**RE: DFT – SITE PLAN ADMINISTRATIVE (PR-2024-011315, SP-2025-00072)
LT 18-A-1 PLAT OF LOTS 13-A-1 & 18-A-1 VISTA CONT .4481 AC
IDO ZONE ATLAS PAGE K-09-Z**

Please see responses to comments for PR-2024-011315_SP-2025-00072:

ROUTE 66 STORAGE ALBUQUERQUE, NM	DRAWN BY AS
	SITE PLAN	DATE 09/24/25
	TIERRA WEST, LLC 5571 MIDWAY PARK PLACE NE ALBUQUERQUE, NM 87109 (505) 858-3100 www.tierrawestllc.com	SHEET # C-1
RONALD R. BOHANNAN P.E. #7868	09/24/25	JOB # 2022105

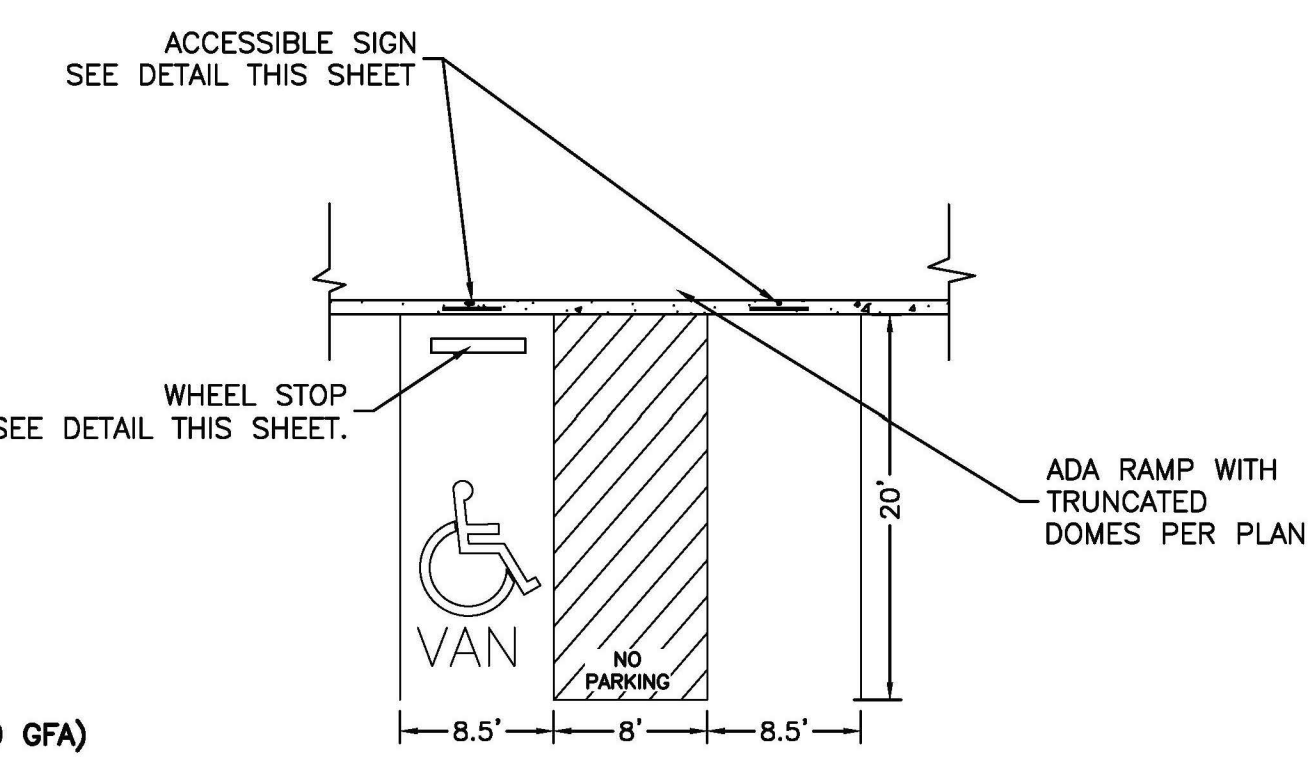
1. 4-3(D)(29)(d) Within 100 feet in any direction of any Residential zone district or lot containing a residential use in any Mixed-use zone district, public access to any storage units is prohibited between 10:00 P.M. and 7:00 A.M. This must be added as a note on the Site Plan.

8. List all the variances received on the front page of the Site Plan as an exhibit or note.

2. As per IDO 5-6(F)(1)(a), Parking Lot Edges, since the parking lot abuts the R-MC zone to the east (in the access easement) there is a requirement of a 6-foot high opaque wall screening the R-MC zone from the parking area, as per Neighborhood Edge requirements in IDO 5-9(D)(1)(a):

5-9(D)(1)(a) Where parking or vehicle circulation areas on a Regulated Lot abut a Protected Lot, a minimum 6 foot high opaque wall or fence shall be required to visually screen the parking or circulation area. Chain link fence with slats shall not constitute acceptable screening.

RESPONSE: Acknowledged. This has been added to the revised SP, general note 5.

RESPONSE: Acknowledged. These have been added to the revised SP.

RESPONSE: Acknowledged. The revised SP includes a 6-foot-tall wooden fence.

ROUTE 66 STORAGE ALBUQUERQUE, NM	DRAWN BY AS
	MASTER UTILITY PLAN	DATE 09/24/25
 5571 MIDWAY PARK PLACE NE ALBUQUERQUE, NM 87109 (505) 858-3100 www.tierrawestllc.com	SHEET # C-3	JOB # 2022105
	ENGINEER'S SEAL RONALD R. BOHANNAN NEW MEXICO PROFESSIONAL ENGINEER #7868 09/24/25	2022105_MUE

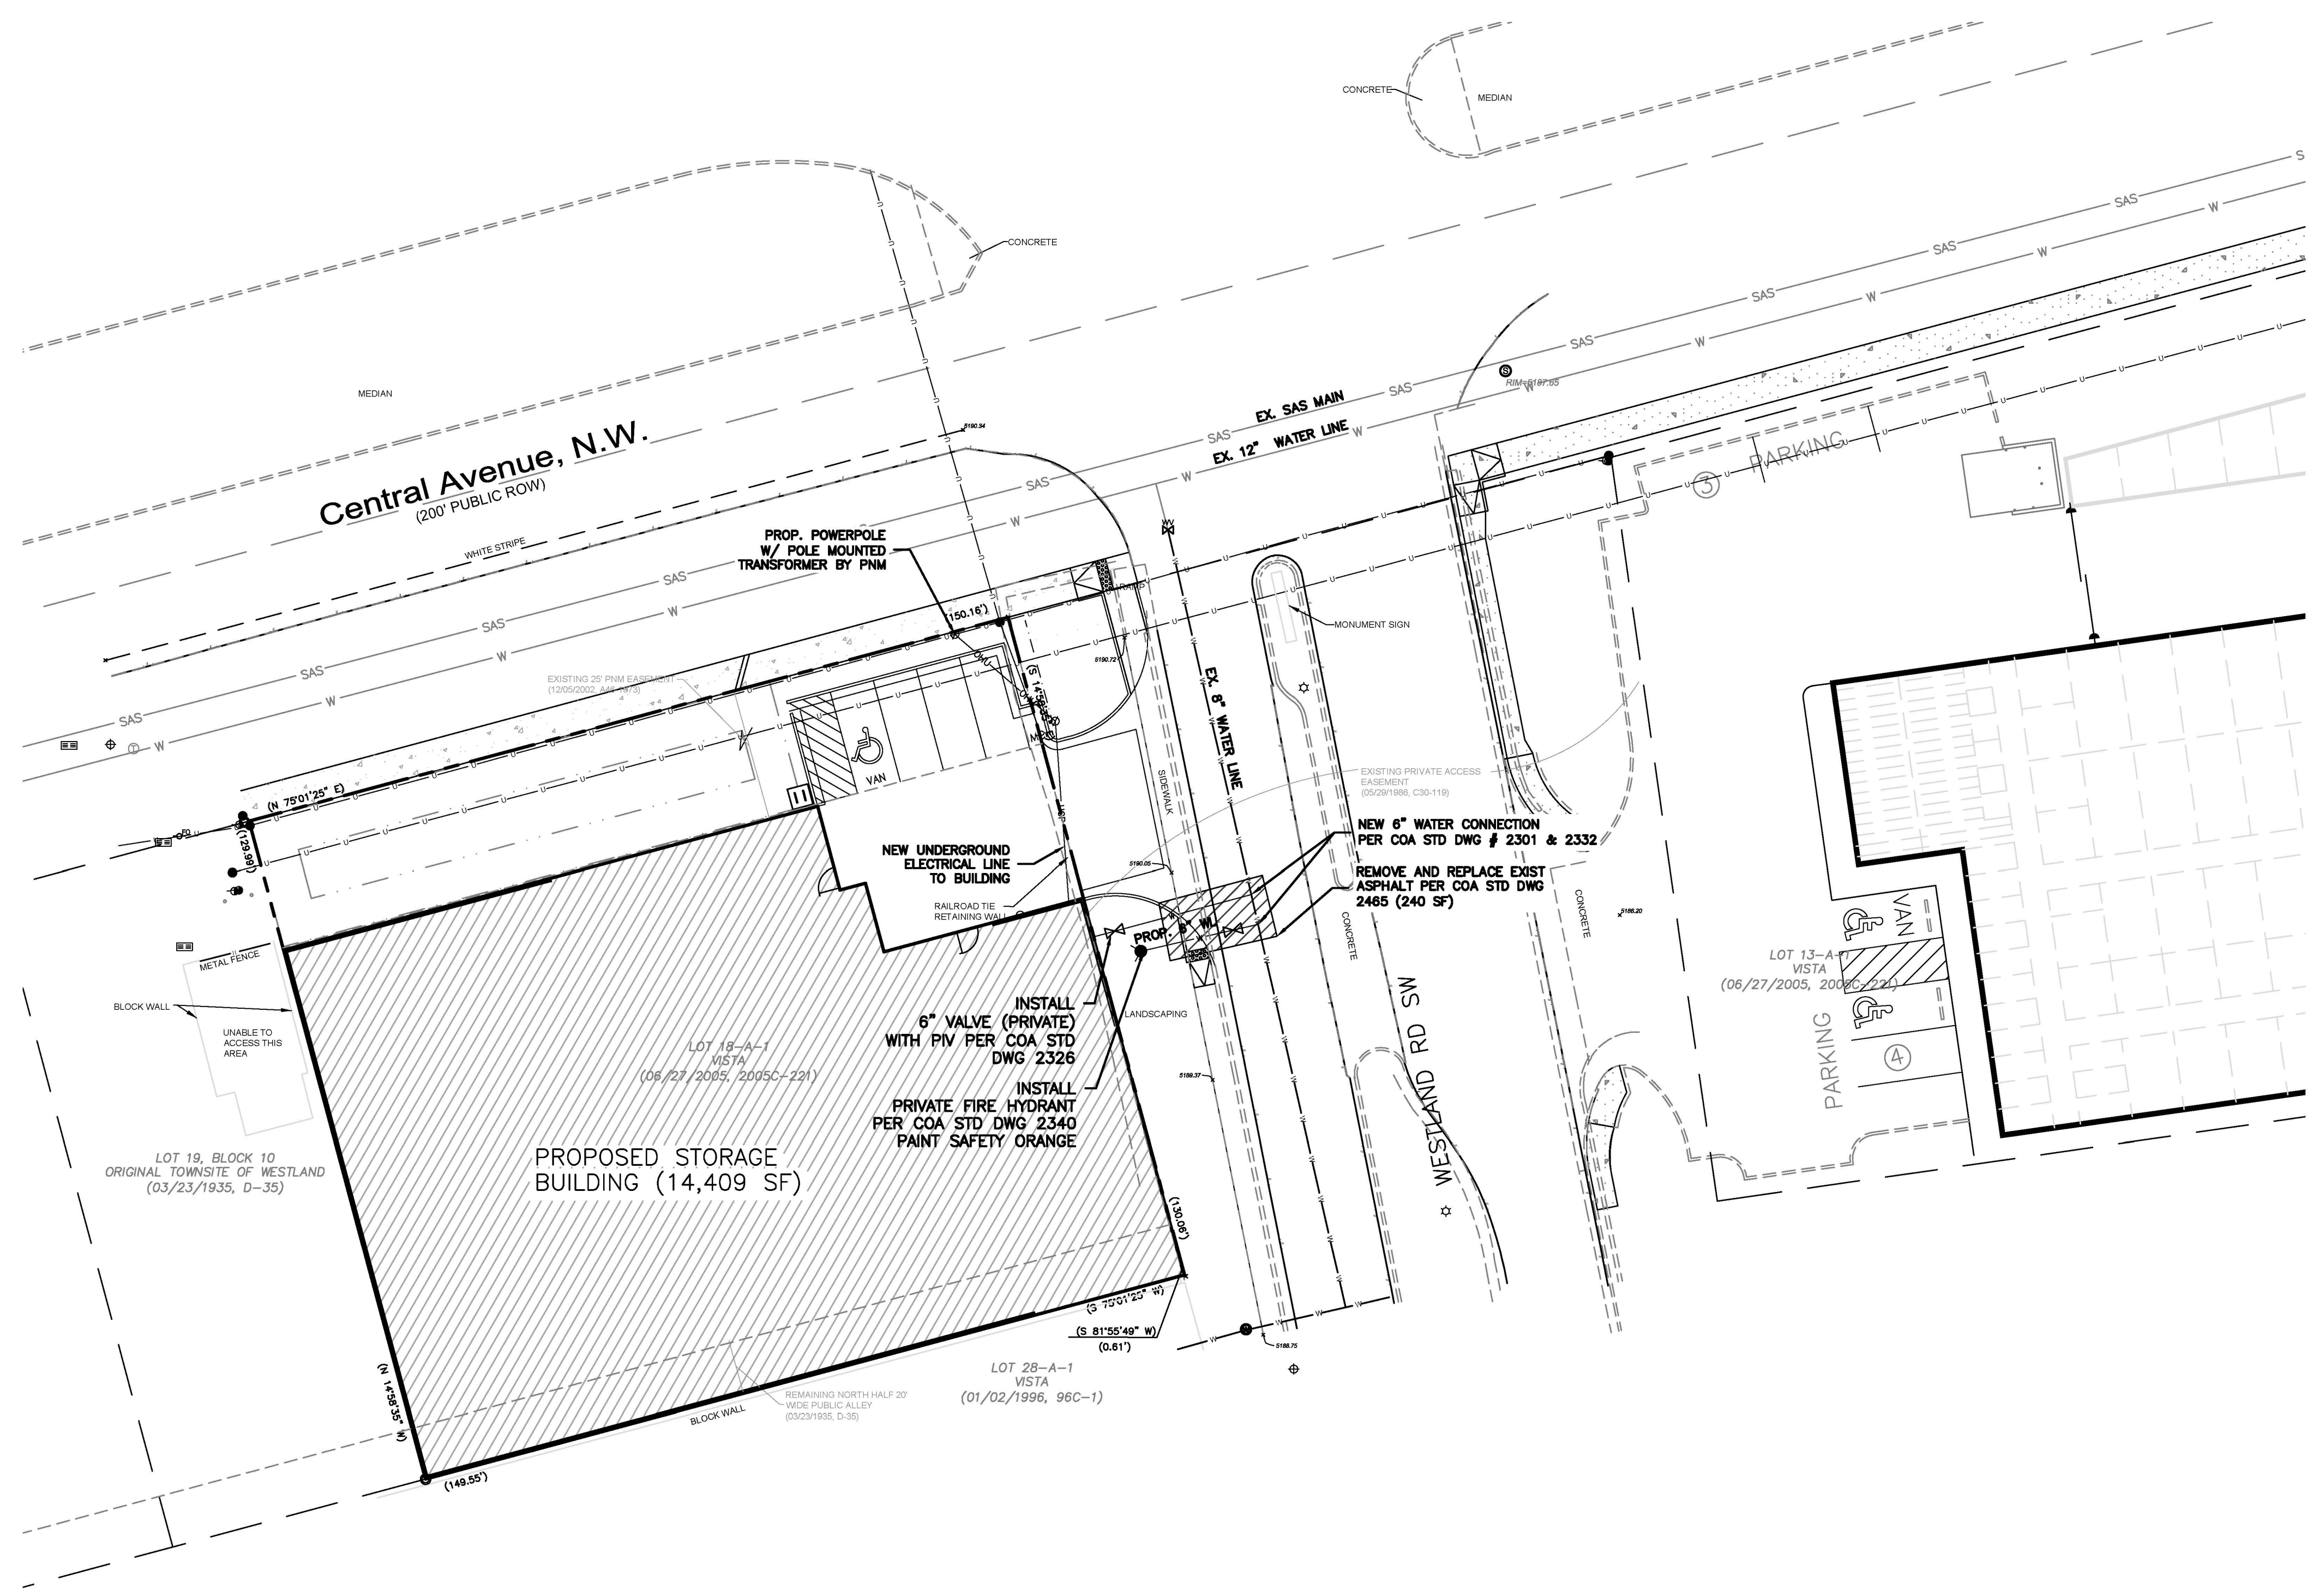
2. The statement specifically required the private fire line to be connected to the existing 8-in water line.

RESPONSE: Acknowledged. This has been adjusted on the revised MU.

Photometric

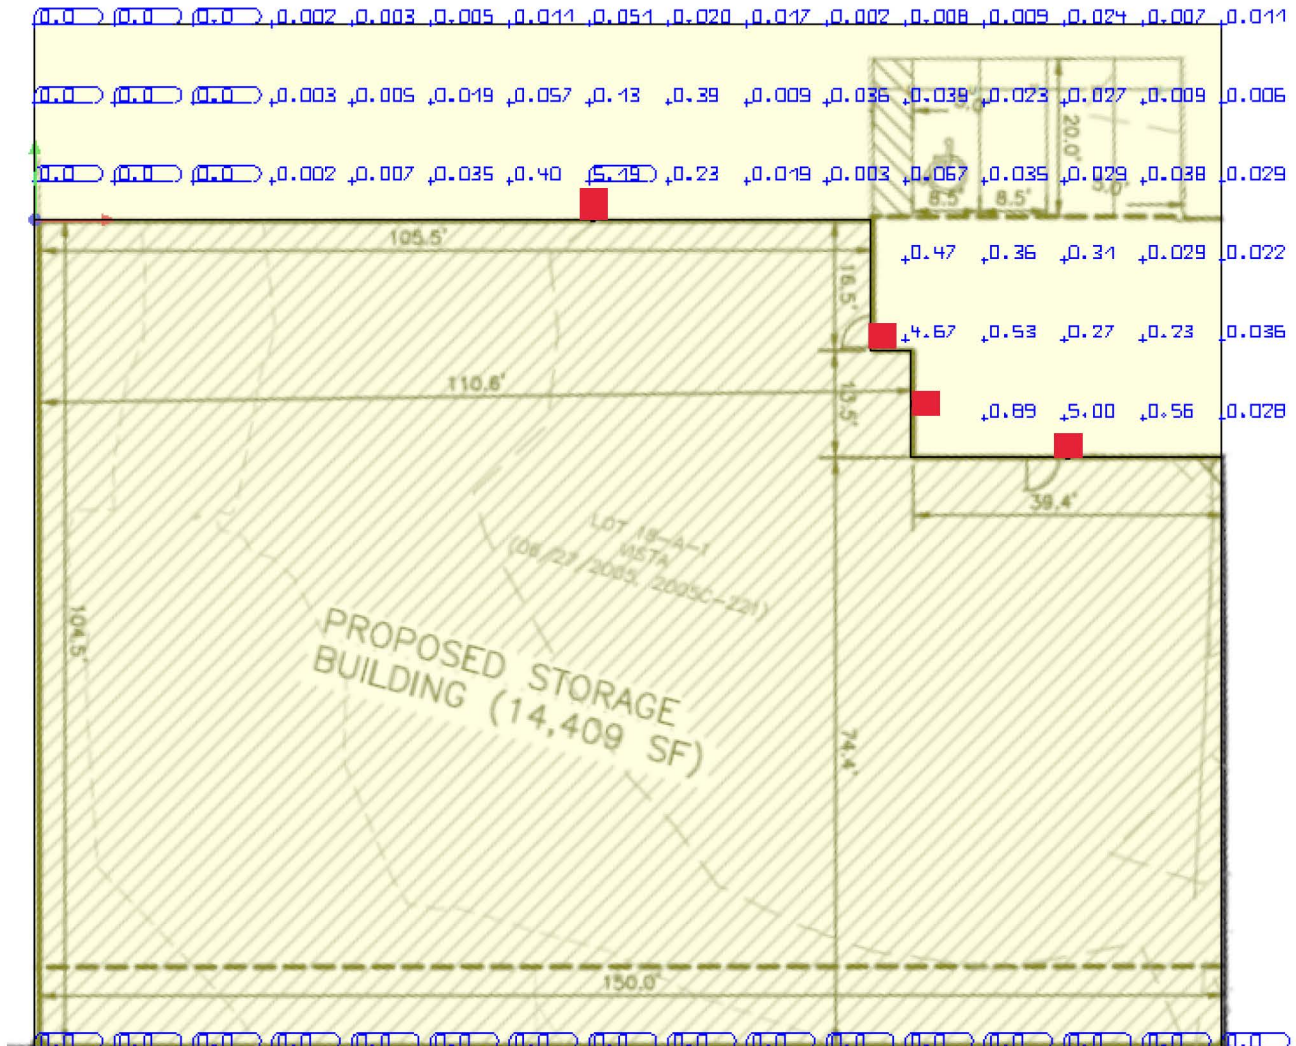
- b. Light Trespass, IDO 5-8(F)(4), Table 5-8-3: Provide a photometric site plan showing how total illumination (from interior and exterior light sources) complies with light trespass requirements at the property line for the LZ-1 light zone (no more than 0.1 footcandles at the property line).

RESPONSE: A photometric study was provided for staff to review. The site has a variance that allows development at the property line, which makes meeting the trespass requirements at the property line delicate.
